Reference No: 2018/62/93031/E

Site Address: 11, Pilgrim Avenue, Dewsbury Moor, Dewsbury,
WF13 3NQ

Description: Erection of extensions to front, side and rear

OFFICER REPORT

PRODUCT No: **HUSS-101** DRAWING No: **PL-01a** REV: **A**

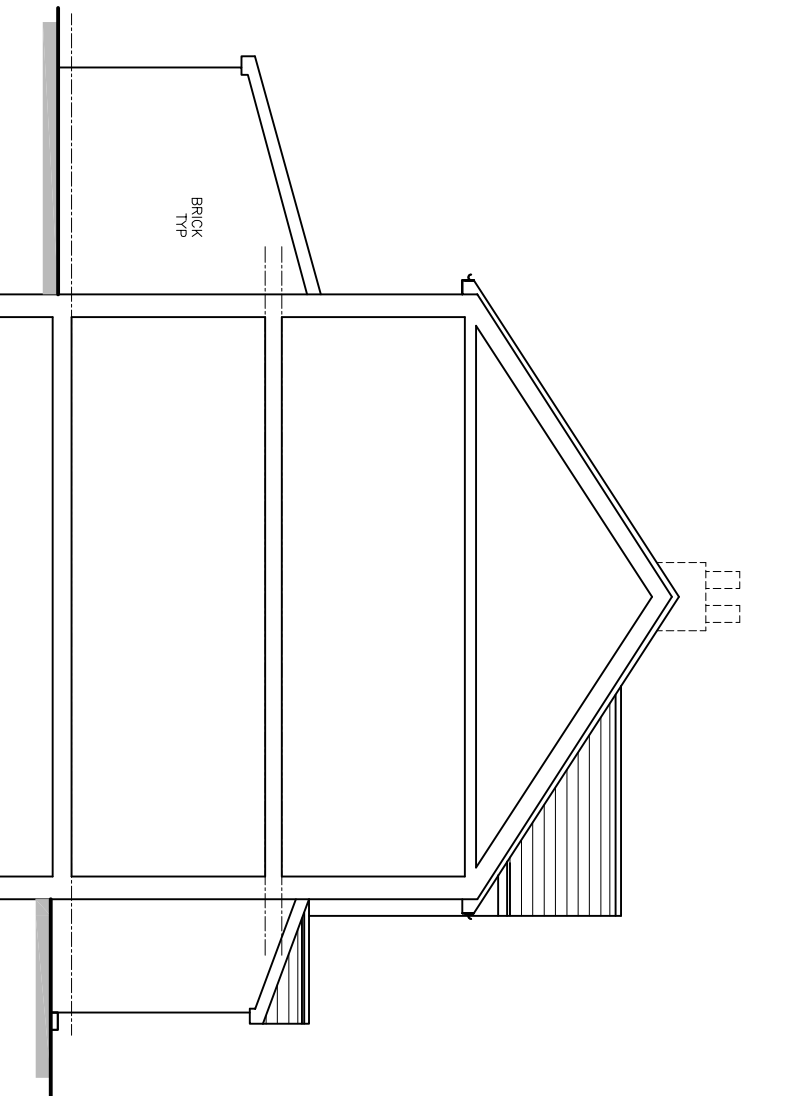
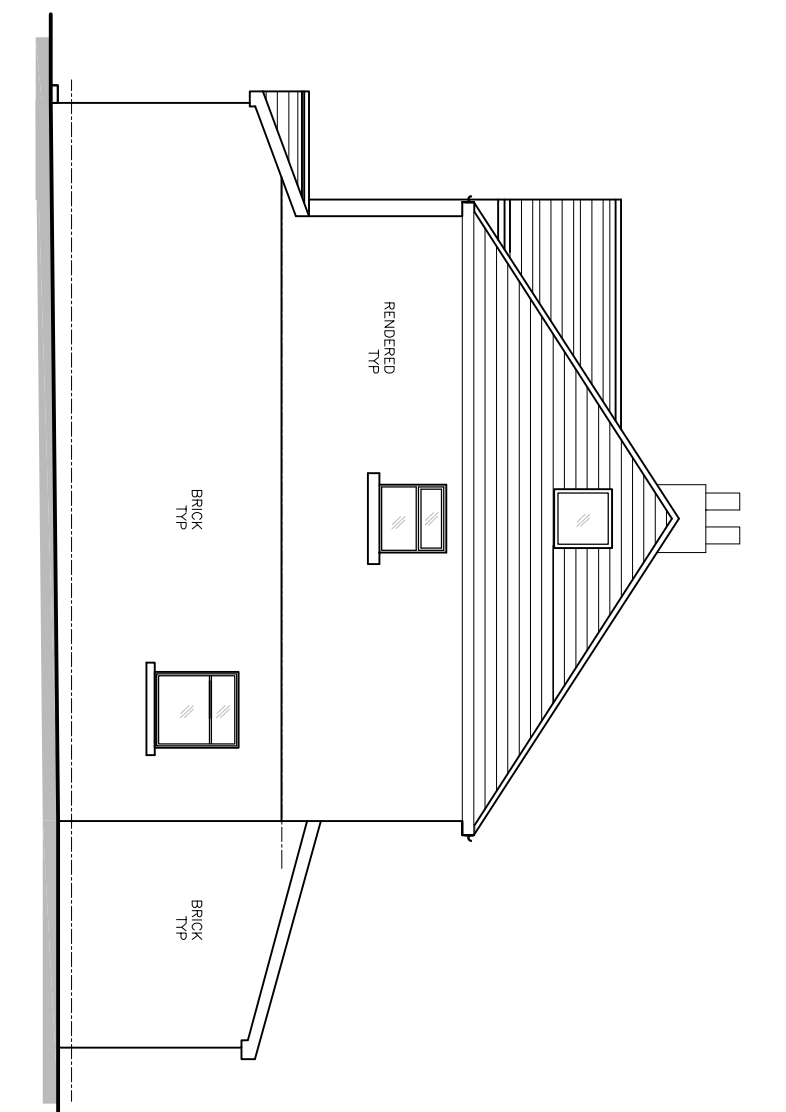
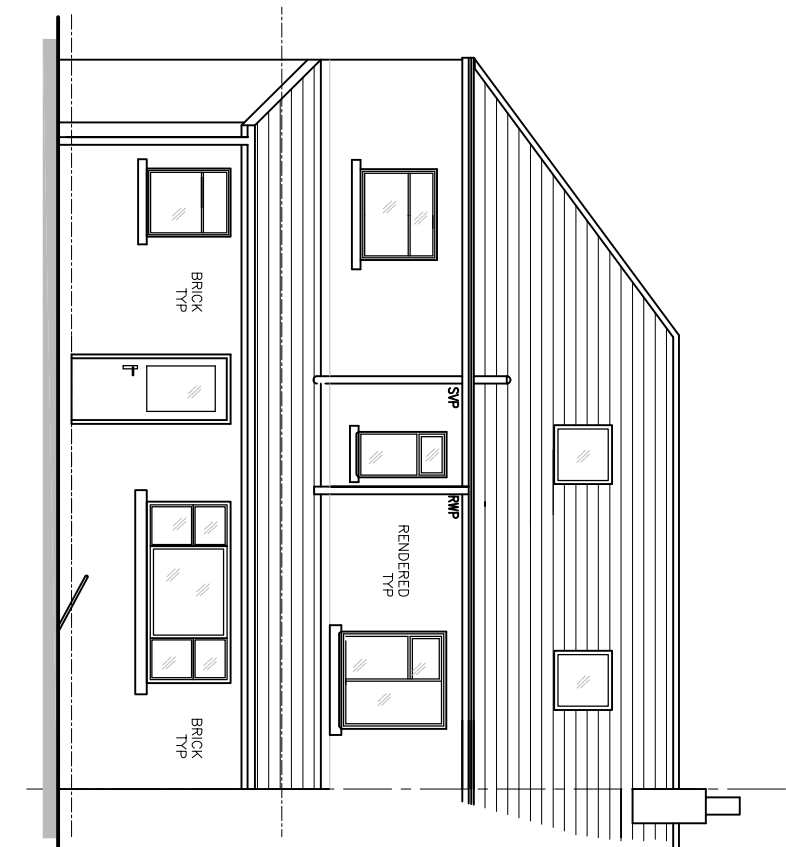
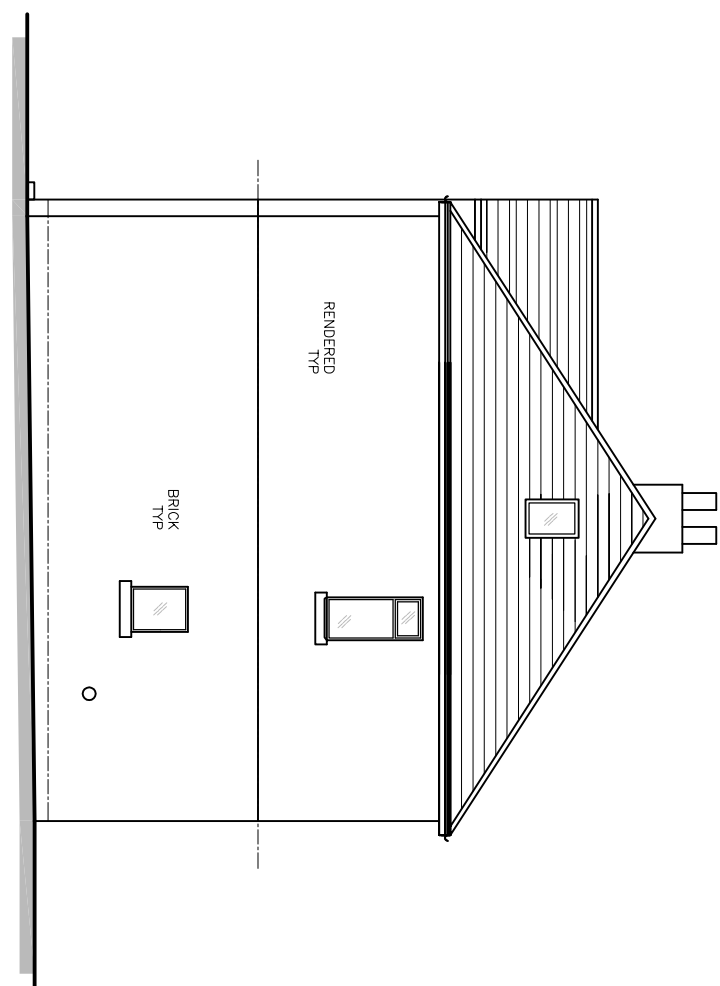
The initially submitted plans included a gabled roof form which, given Pilgrim Avenue is predominately hipped roof forms, would have resulted in the formation of an incongruous feature. As such, amended plans were sought and received on 18/10/2018 to alter the roof over the side extension to a hipped roof form to overcome the visual amenity concerns. The alteration would change the appearance of the extension from that initially advertised. As such, the neighbours have been offered the opportunity to comment on the amended plans until 28/10/2018.

The initially submitted plans included a gabled roof form which, given Pilgrim Avenue is predominately hipped roof forms, would have resulted in the formation of an incongruous feature. As such, amended plans were sought and received to change the roof over the side extension to a hipped roof form to address the visual amenity concerns.

The two storey side extension would project 3.8m from the original side elevation of the dwelling. It would extend the full depth of the original house lying flush with the front and rear elevations with a hipped roof form.
